# Rezoning Transportation Analysis

Petition Number: #2022-218

**From: Jake Carpenter, PE**

Date	Description
05-24-23	First Review (ME)
06-21-23	Second Review (DR)
08-16-23	Third Review (ME)
09-26-23	Fourth Review (IW)

CONCEPTUAL SITE PLAN
REZONING PETITION #2022-218

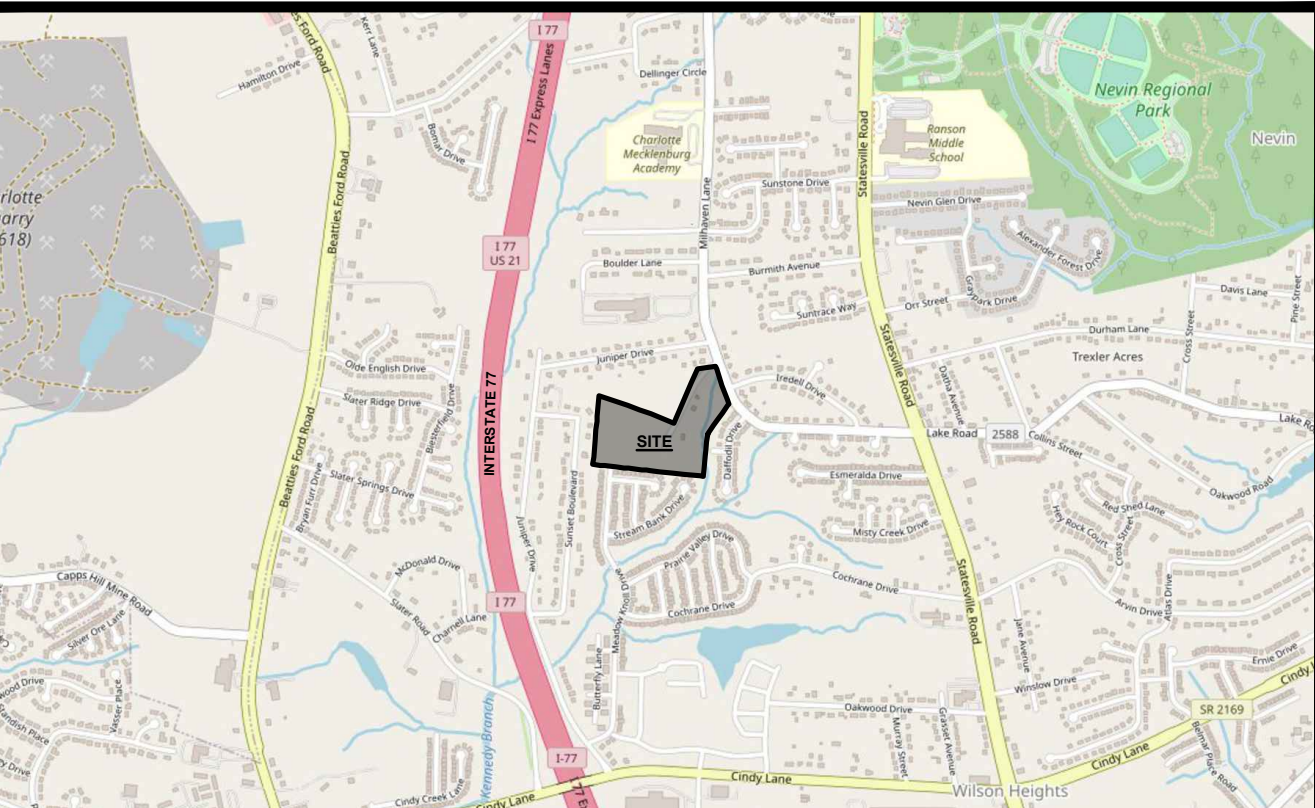
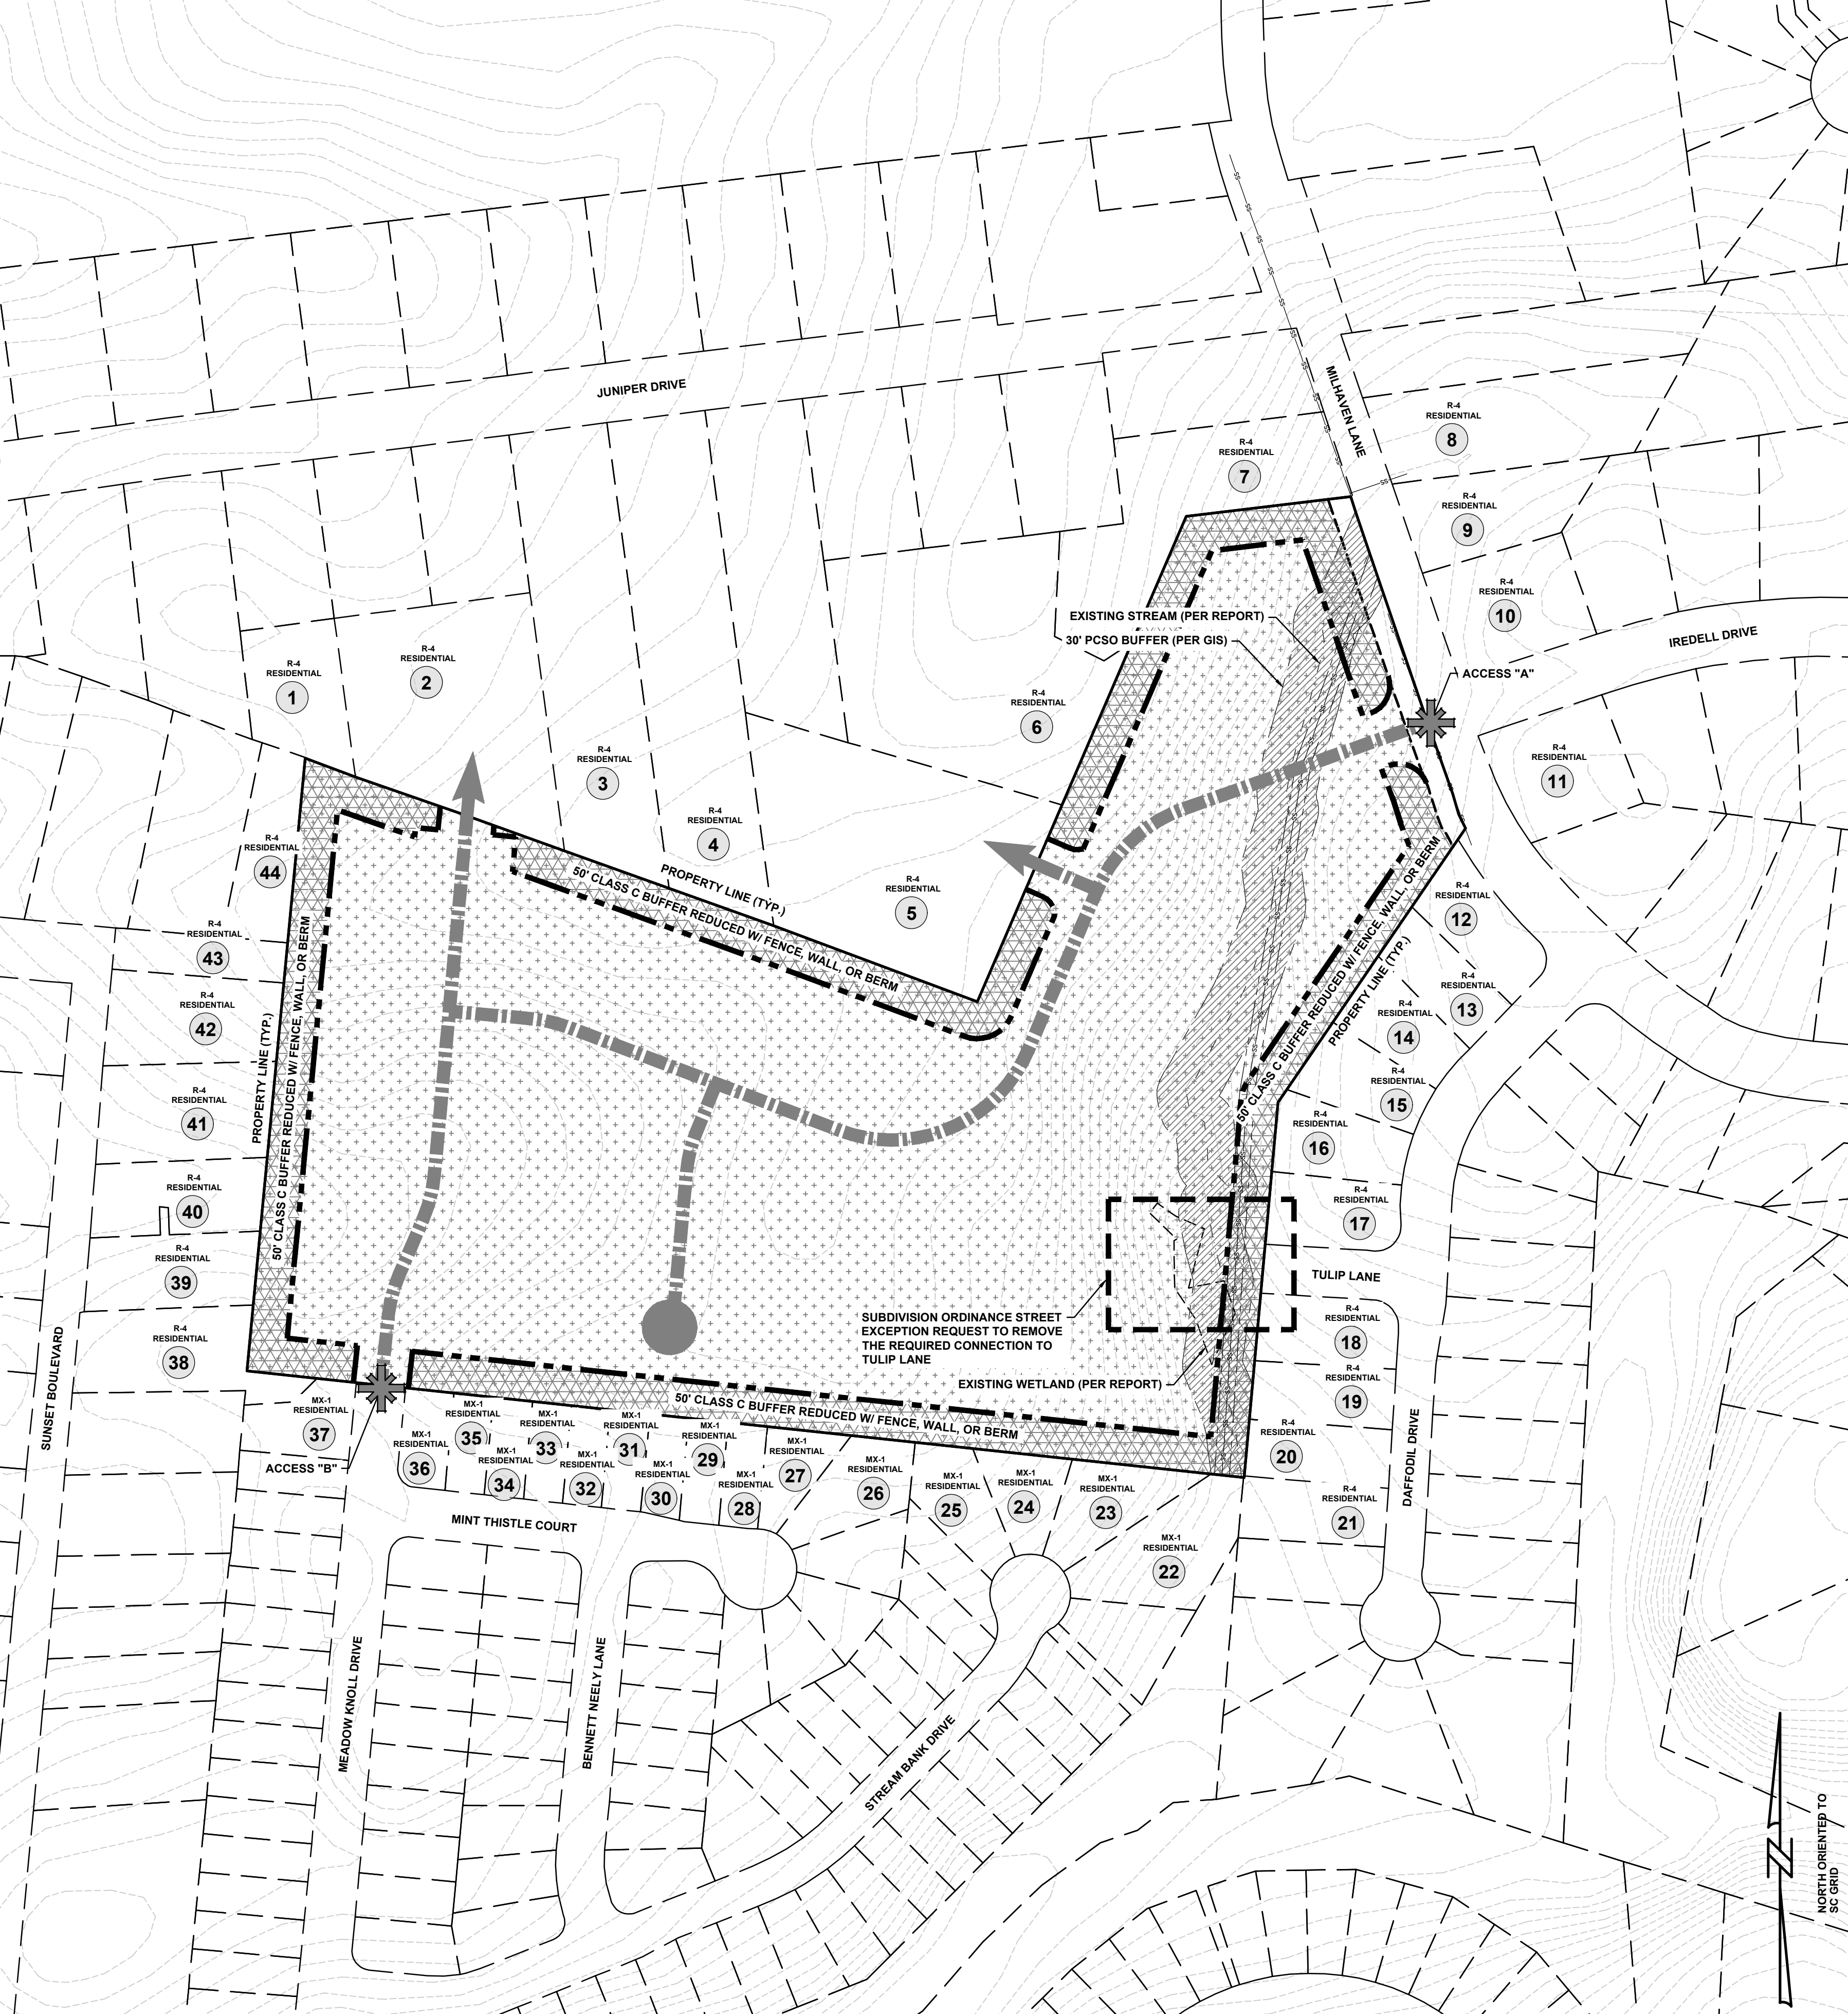
**Clarifying Comment 6.21.23:** ~~Label and dimension 8 foot planting strip and 5 foot sidewalk along internal public streets.~~

3. ~~Revise site plan and conditional note(s) to commit to dedicate 36 ft right-of-way from the road centerline. The site plan shall label and dimension the right-of-way from the road centerline.~~
